Application no: 23/00977/OUT

Location: OS Parcel 9195 North Of, Claydon Road, Cropredy

Transport Schedule

Title :
Proposed Site Access & Visibility Splays

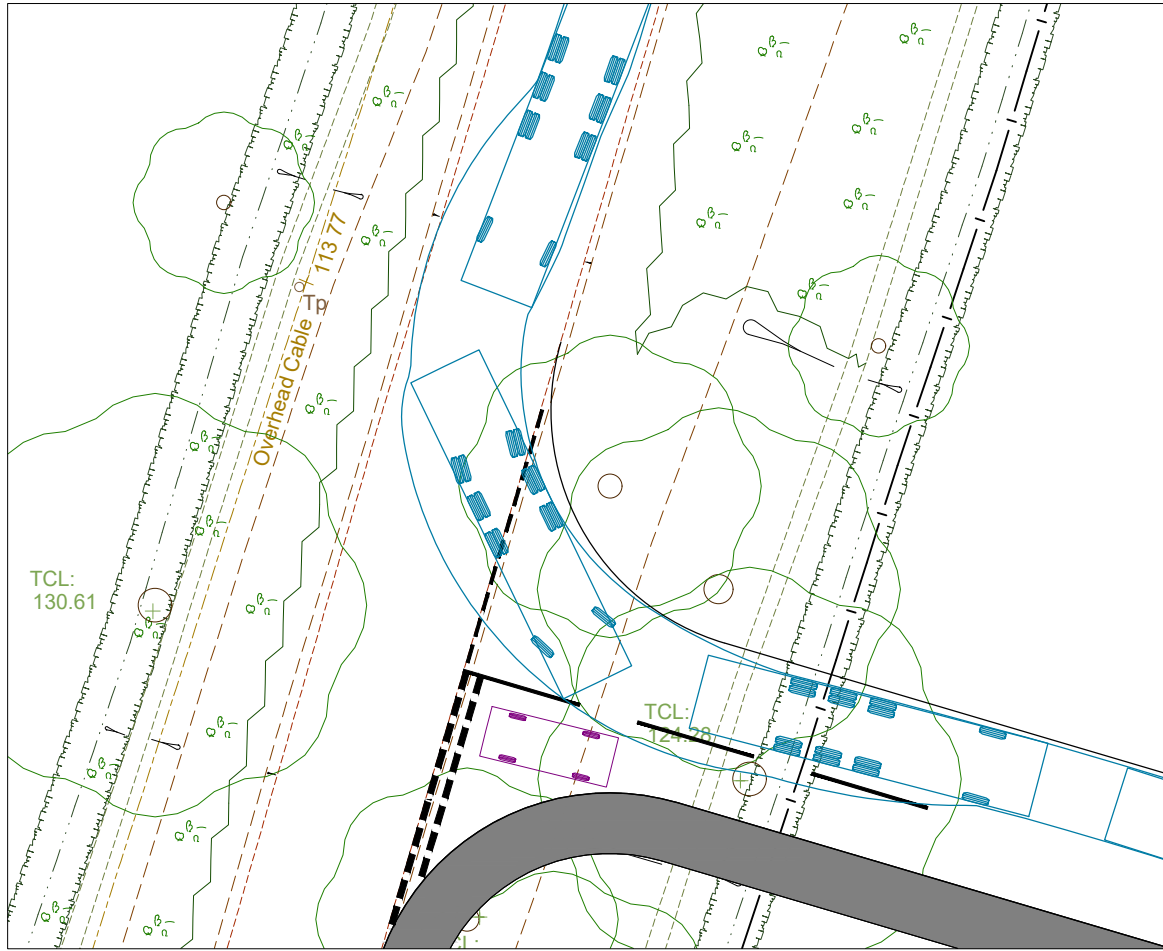
- Amendments needed to access arrangements drawing
- Clarification required on proposed bridge over canal

However, in our response of August 2023 we requested amendments and clarification to the access arrangements drawing, and clarification regarding the proposed bridge over the canal. This does not appear to have been addressed.
